Department of Transportation

August 31, 2026

RE: Trinity Ranch Preliminary Plan (SP268)

K:\COS\_Civil\096726003\_Trinity Ranch\CADD\Exhibits\2026-0415\_Drainage Maps\EX\_DM.dwg Schwenke, DJ 7/29/2026 11:17 AM

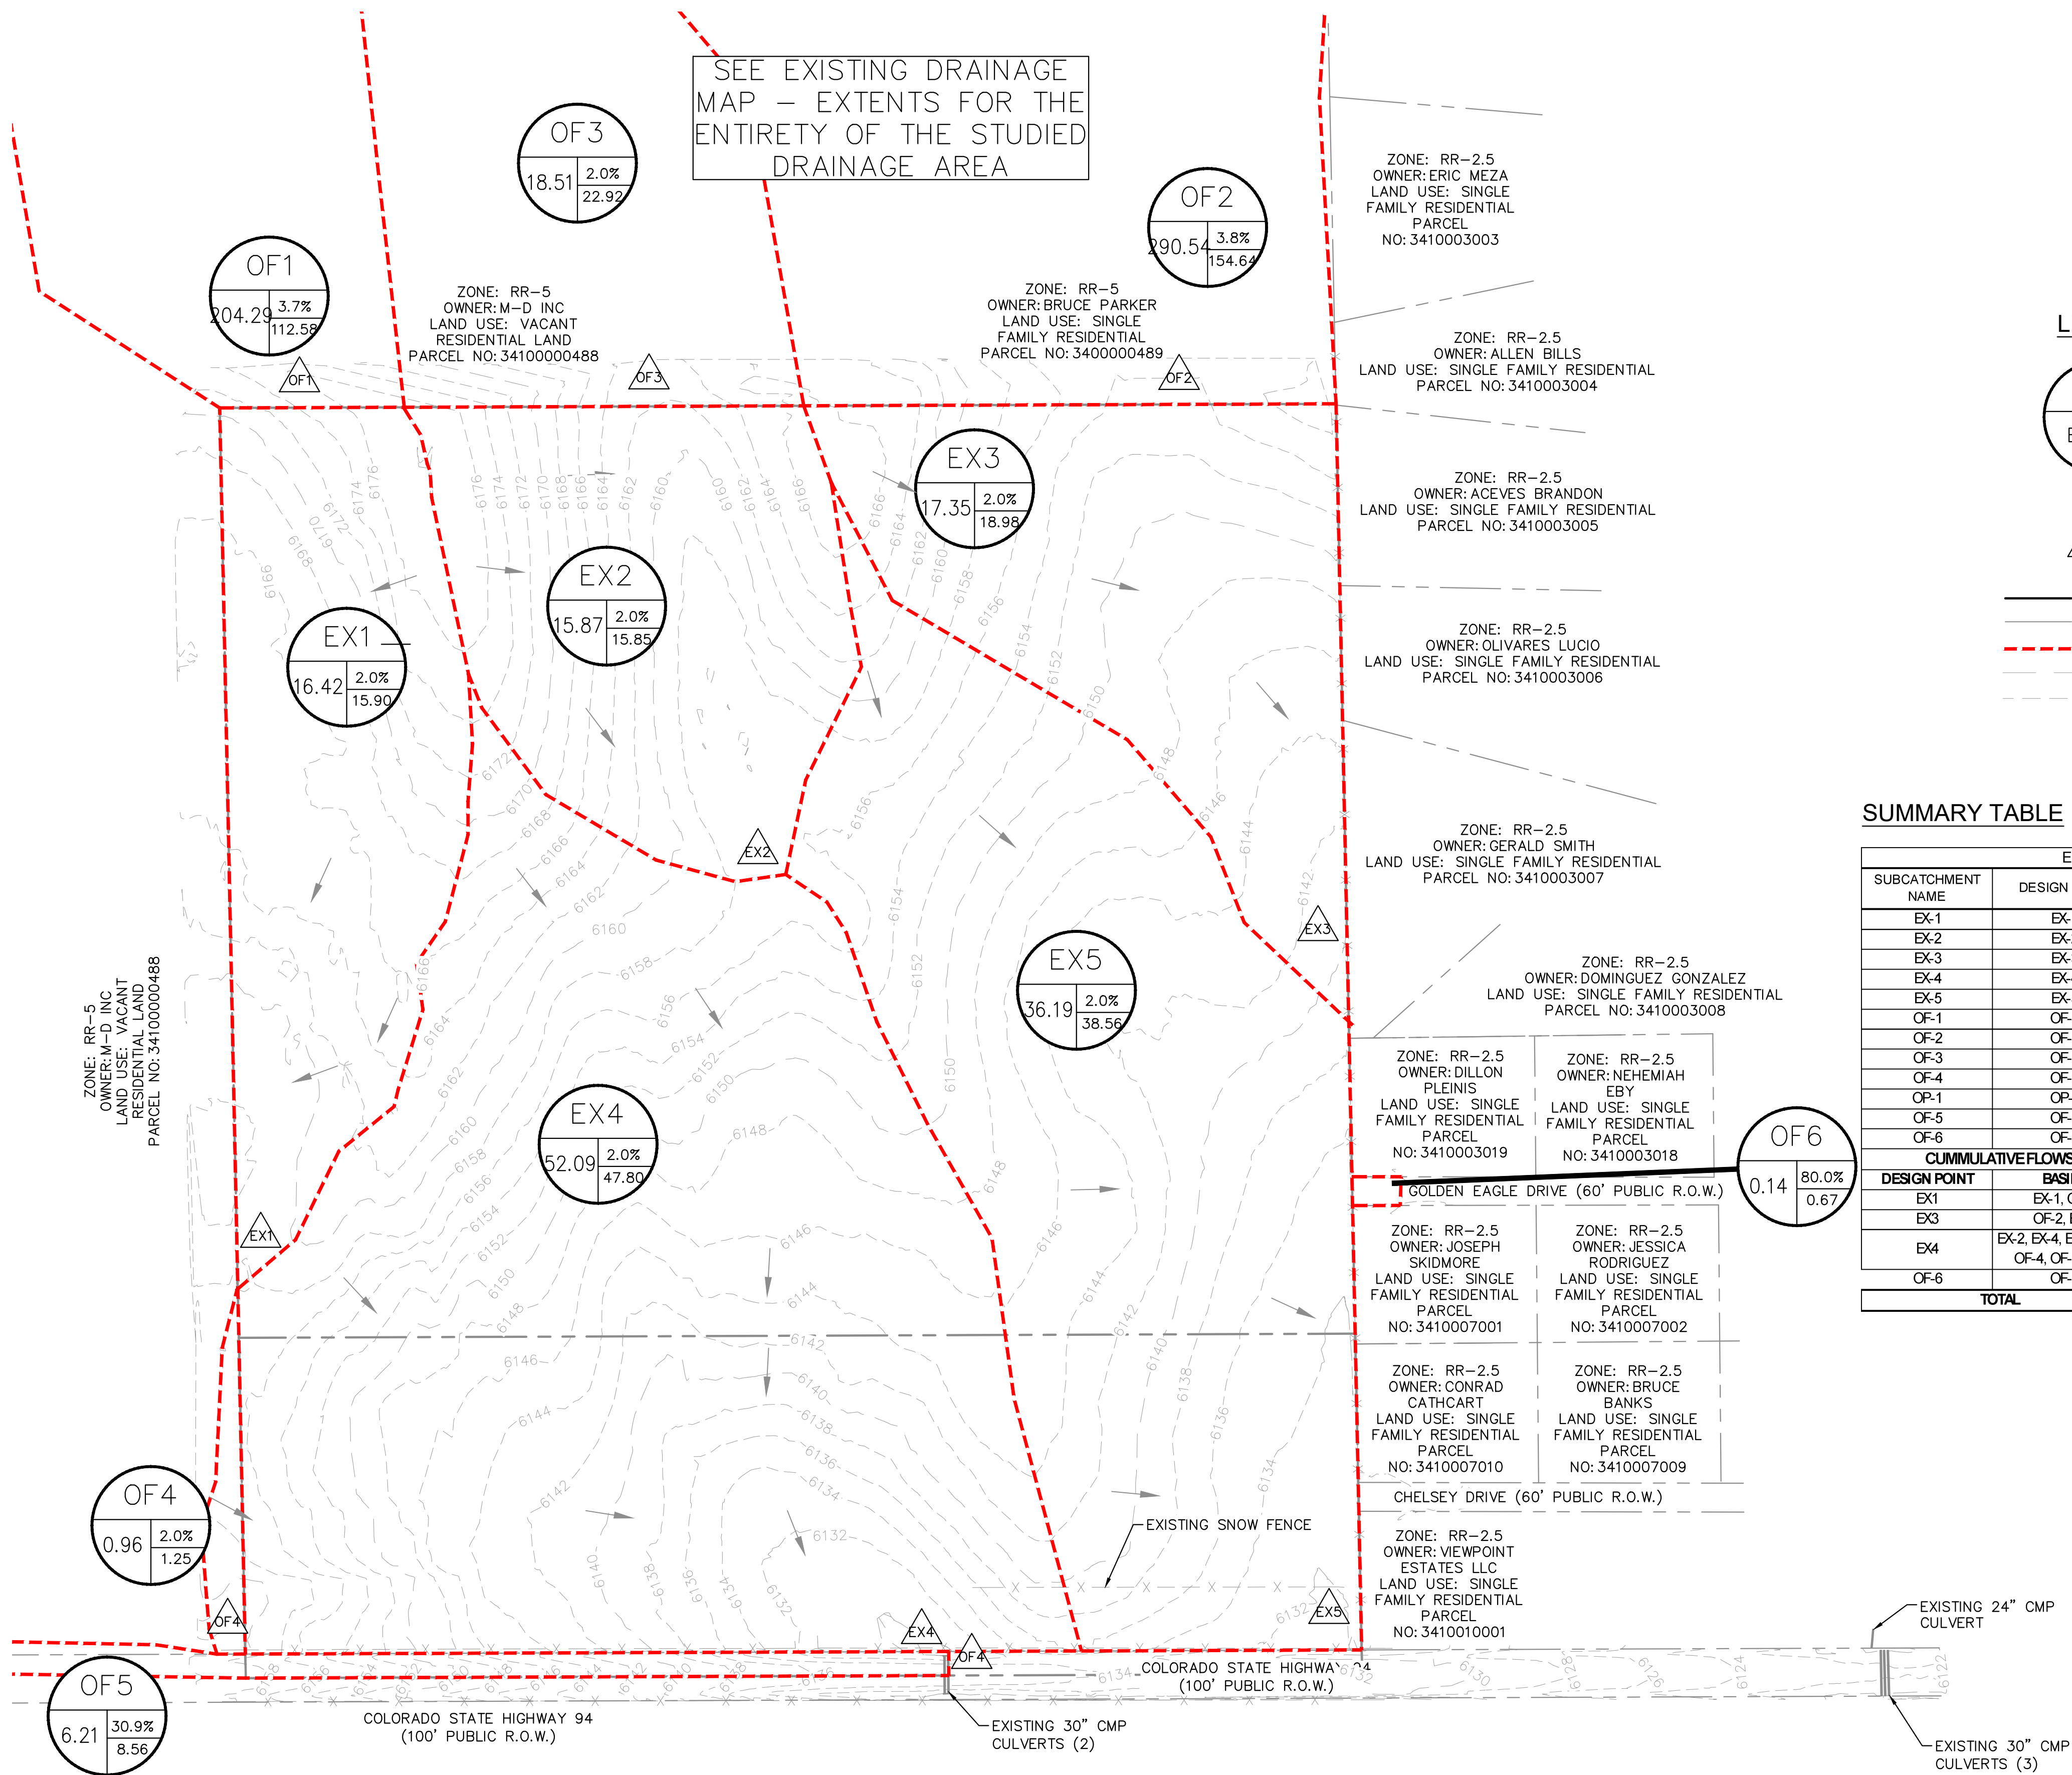
- FYI – PDF pg 82 – OP-1 missing from the drainage map.
- PDF p 82 – The Q100 for EX 5 is 38.56 cfs, the same location is identified as PR9 in proposed and shows an increase in Q100 to 61.78 cfs. Include ditch and culvert analysis to verify impacts to the CDOT ditch and to the 3-30" CMP culverts east of PR9 when the pond is overtopped.

- PDF p 82 – The Q100 for EX 4 is 127.17 cfs, the same location is identified as PR8 in proposed and shows an increase in Q100 to 155 cfs. Include ditch and culvert analysis to verify impacts to the CDOT ditch and to the 2-30" CMPs under the highway when the pond is overtopped.
